# **Application by Mallard Pass Solar Farm Limited for an Order Granting Development Consent for the Mallard Pass Solar Project – project ref. EN010127**

**Tony Orvis B.Sc Hons. (Botany)  
Unique ID ref. 200335950**

## **ExQ1 - Responses to ExA's First Written Questions**

Z:\7863_NSIP_SOLAR_FARM_CONFIDENTIAL\7CAD\DRAWINGS\7863_301_ILLUSTRATIVE_LAYOUT_SAT STRING.DWG

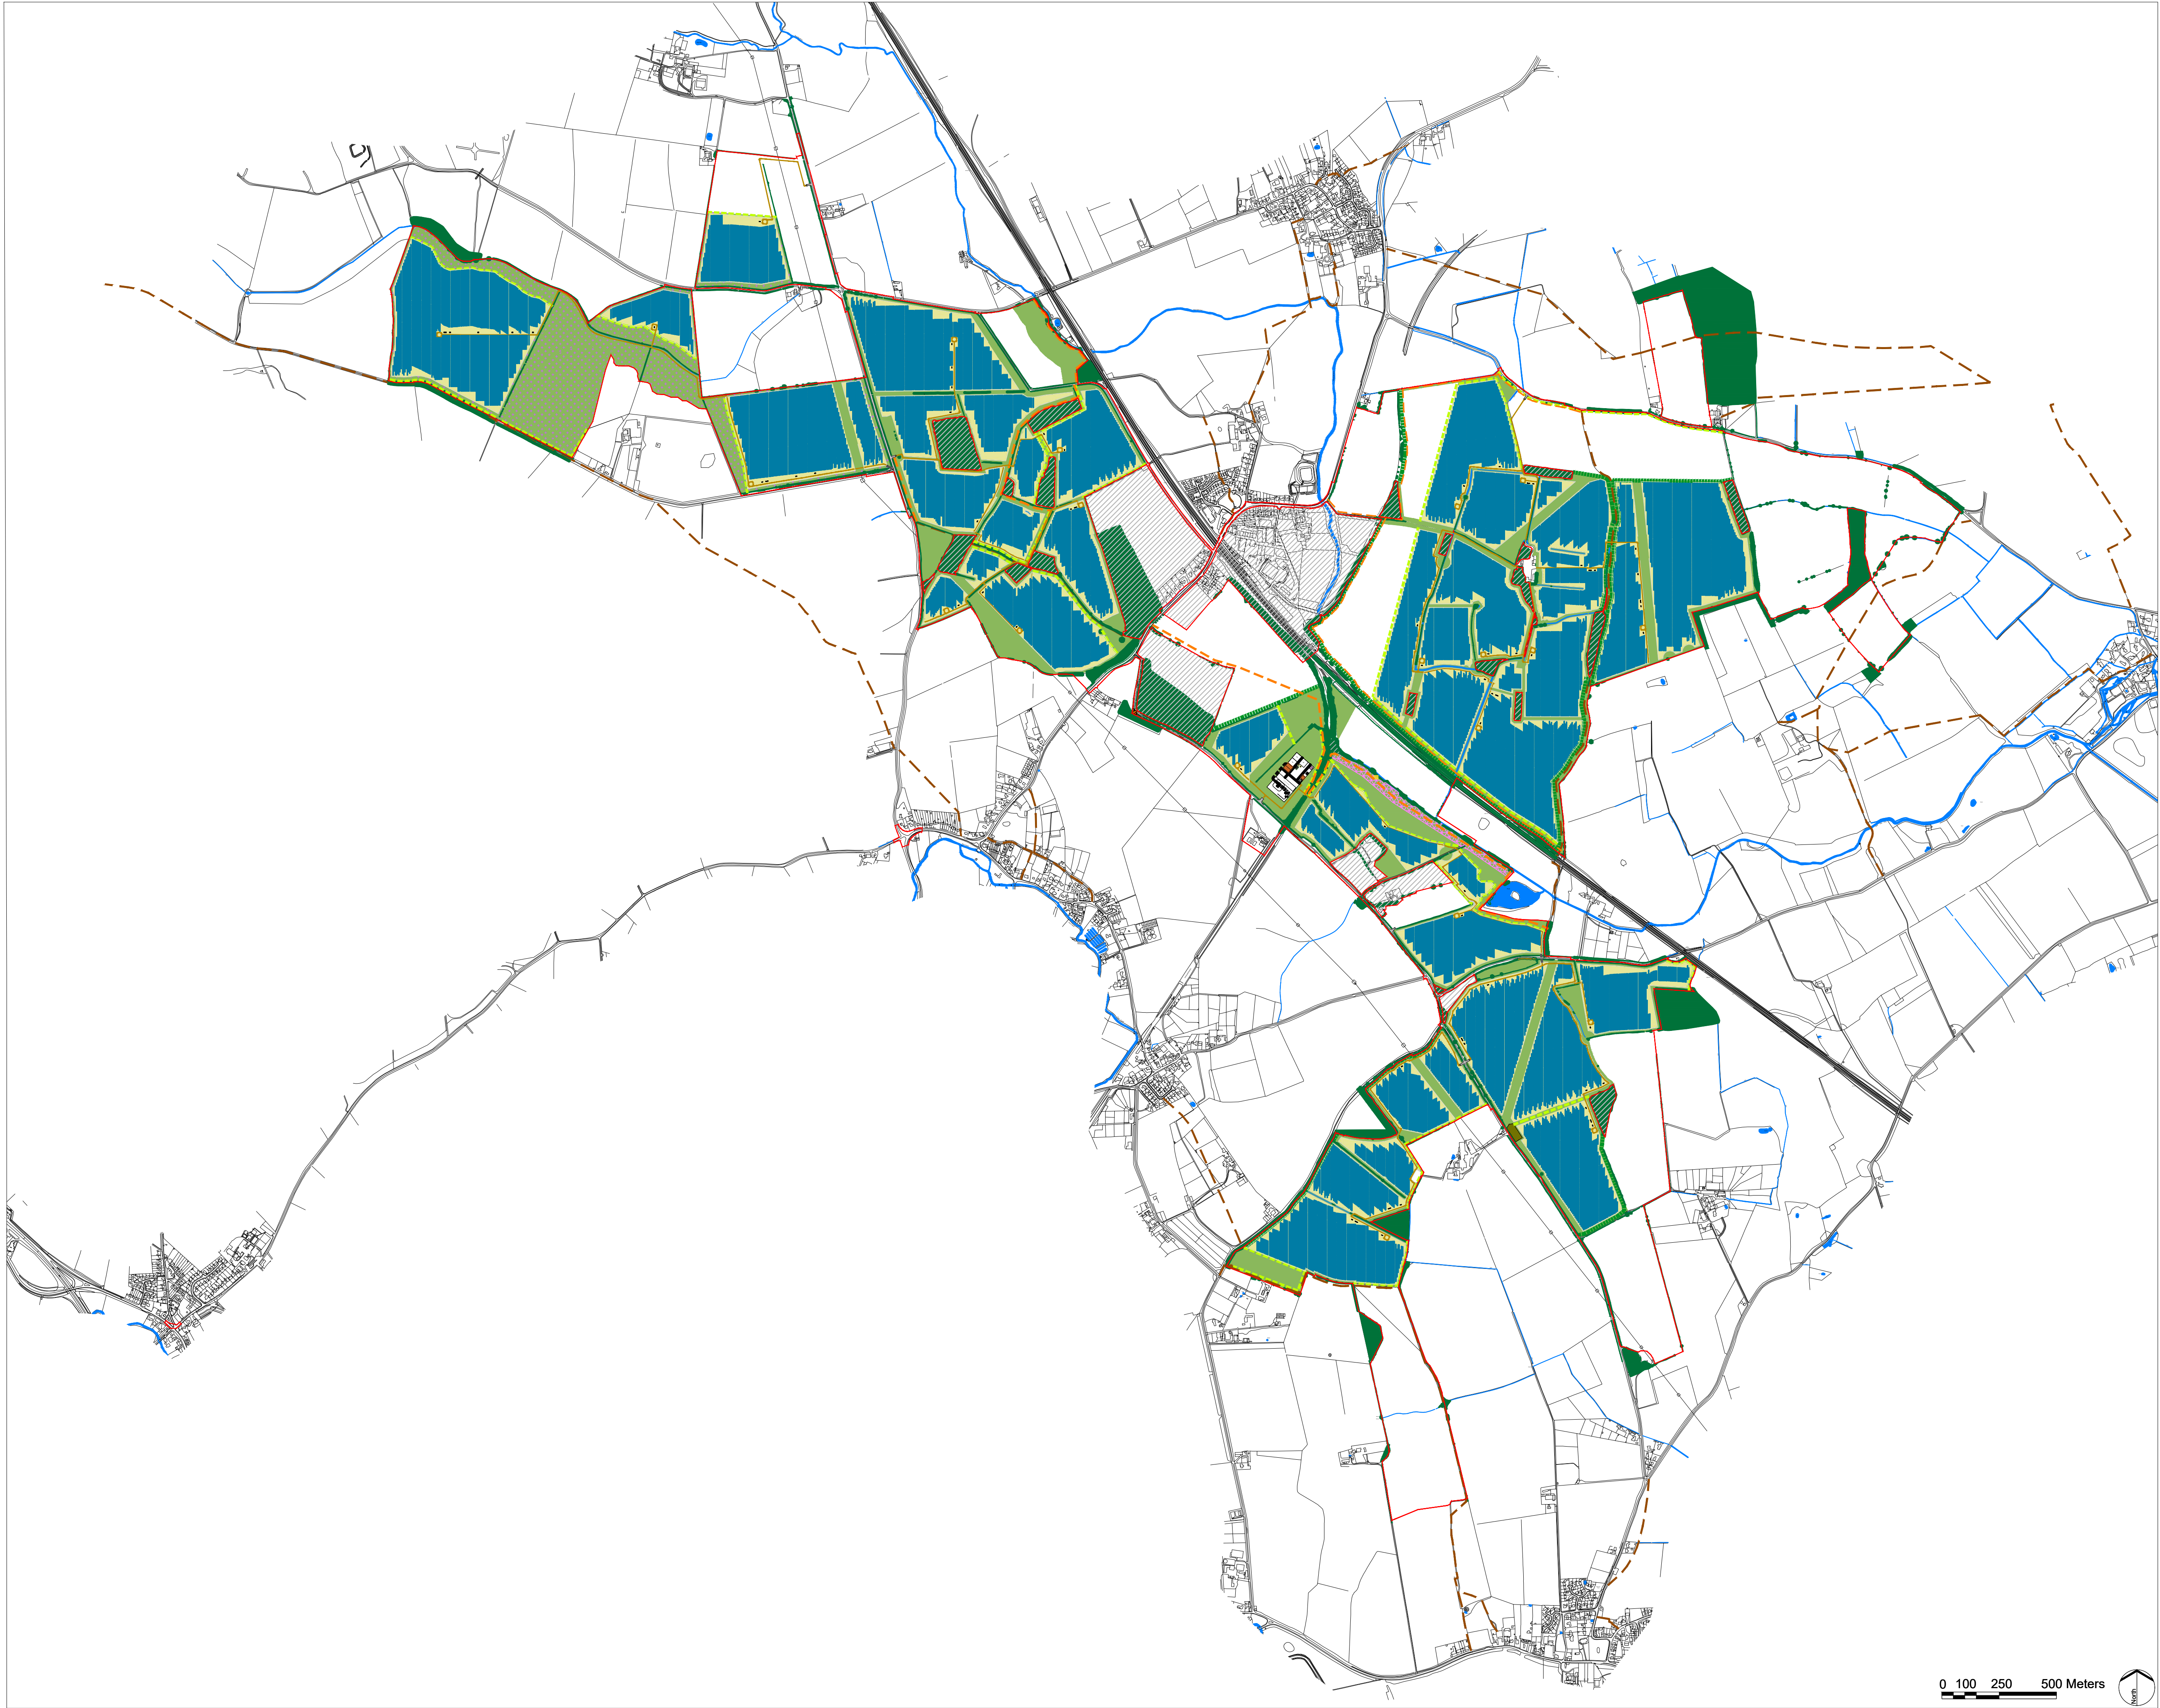
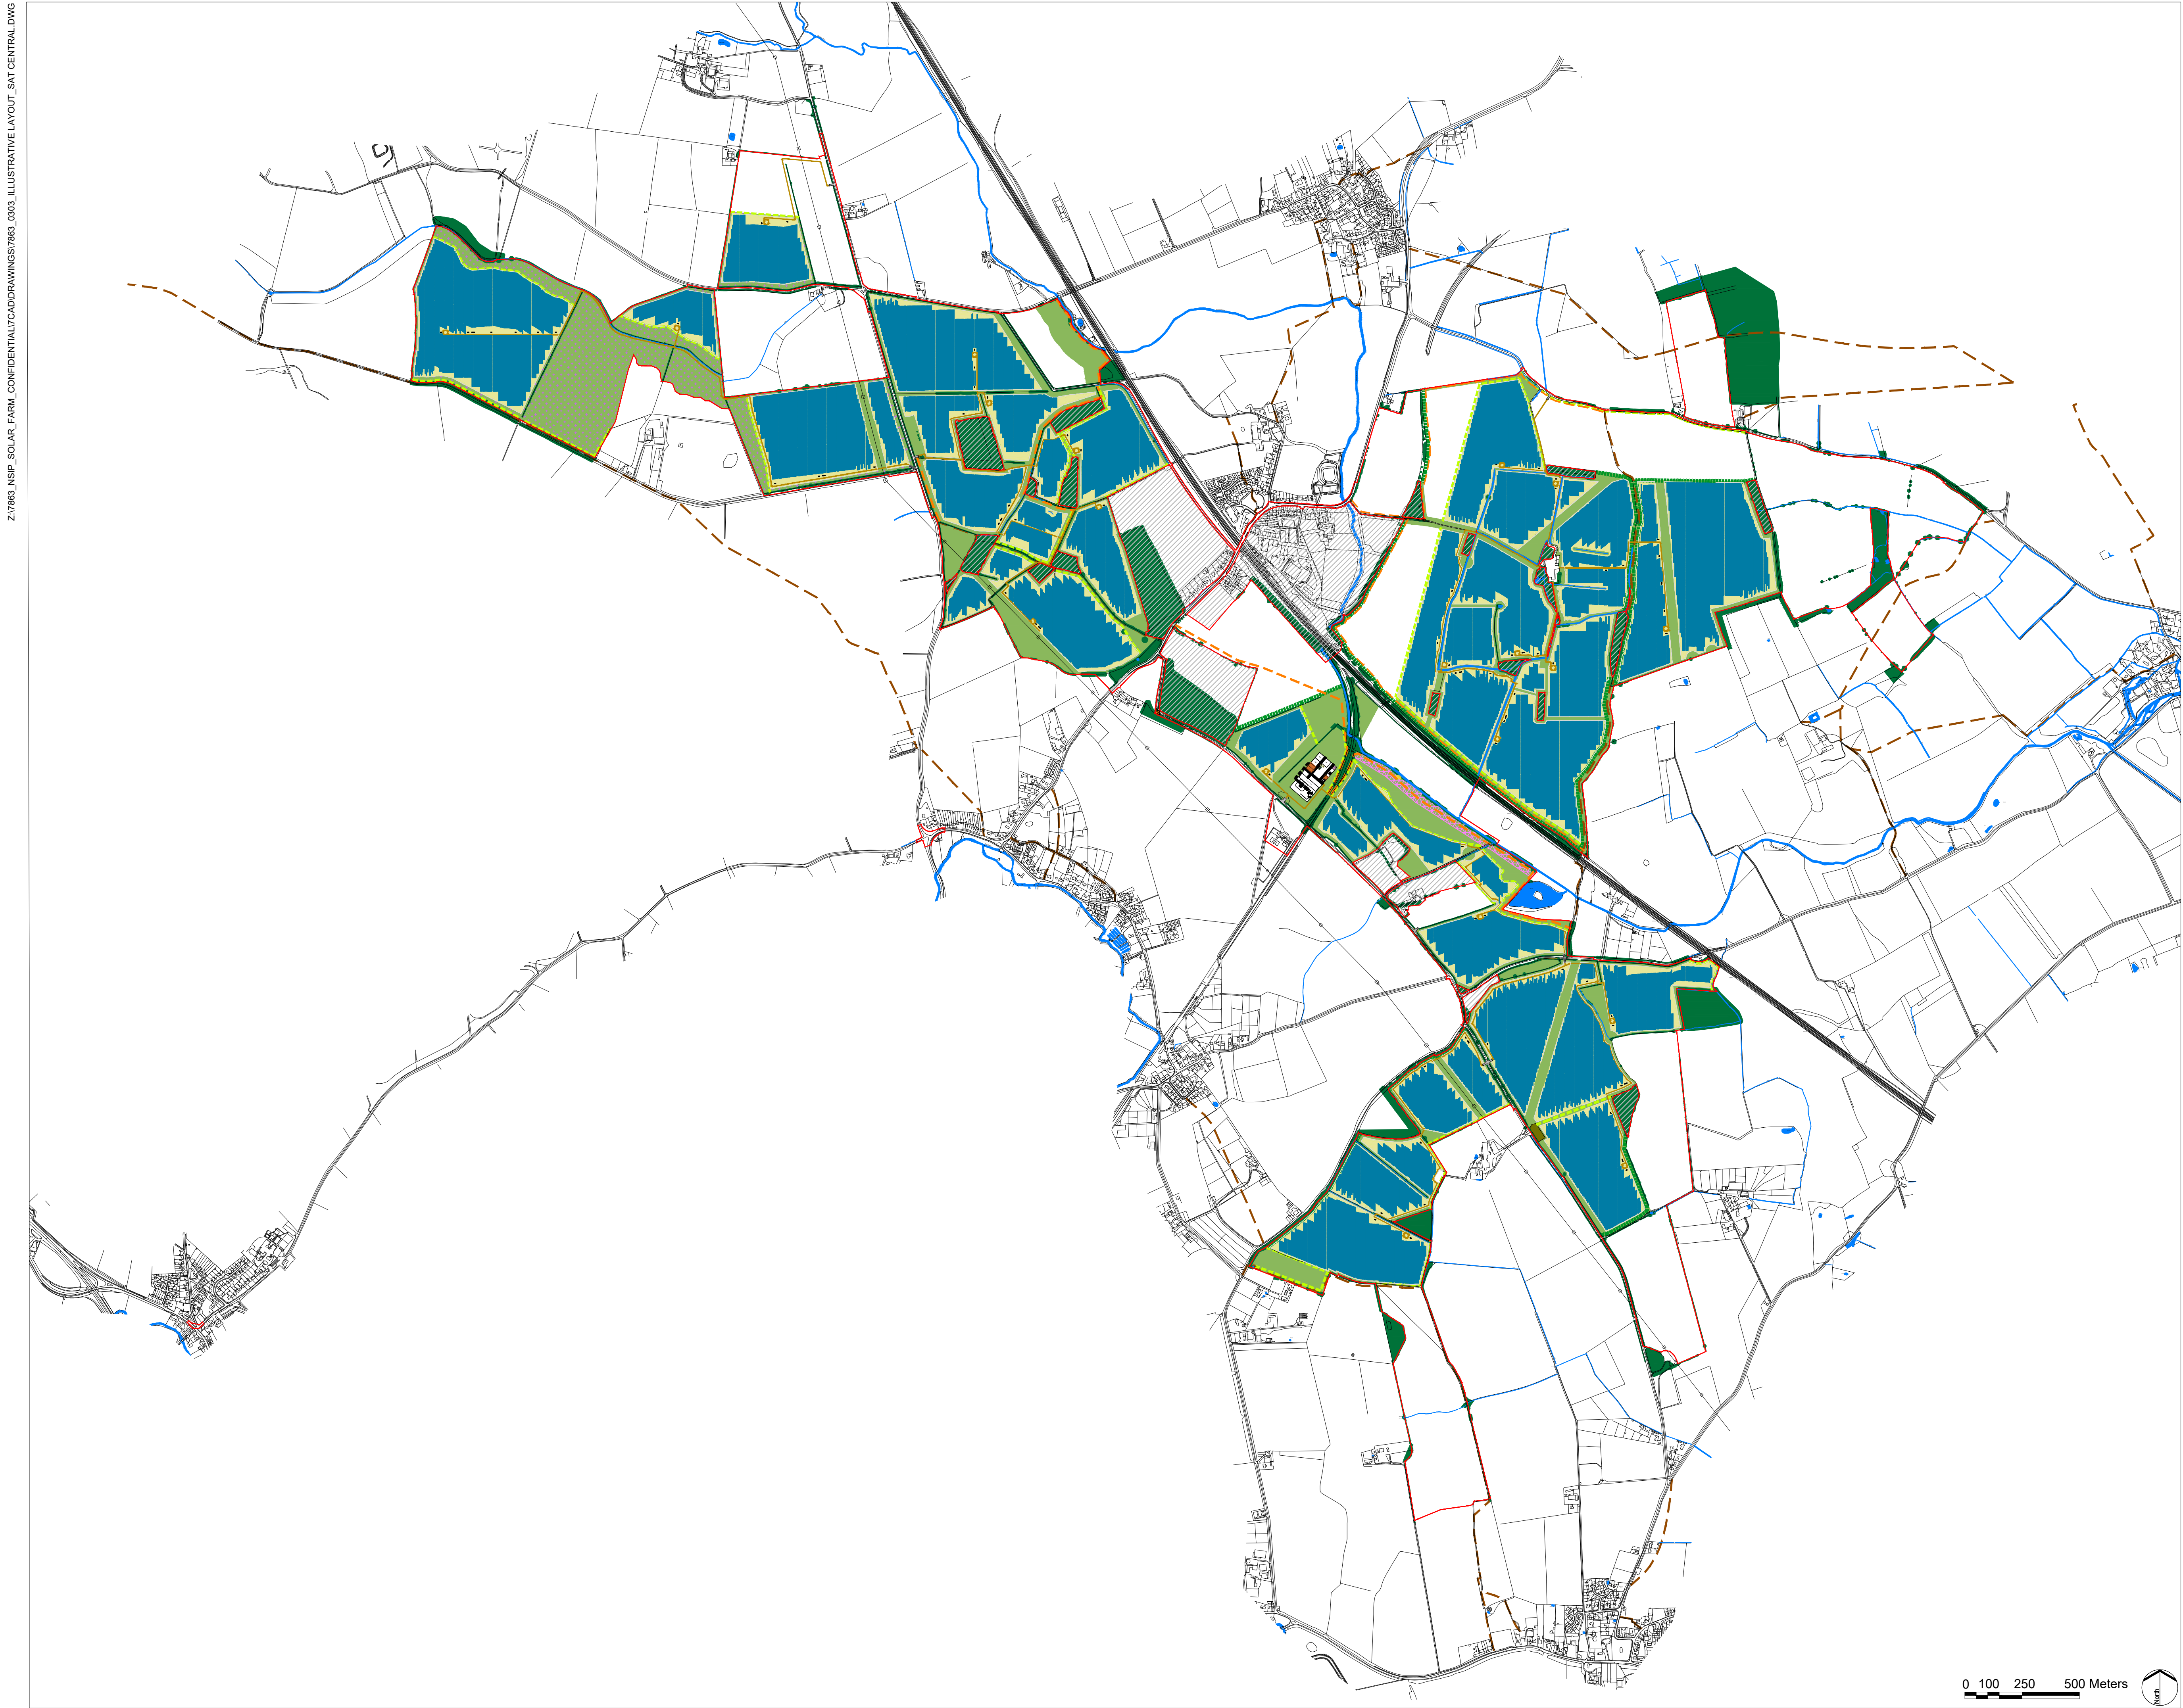
Producing forage, hay, silage or haylage would be impossible. The Applicant does not give the proposed distance between the arrays but states that at a minimum they will be two metres apart “to minimise effects of shadowing and to ensure optimal efficiency.” Although that is the minimum it is highly unlikely that the distance between the arrays will be great enough to accommodate forage harvesters.
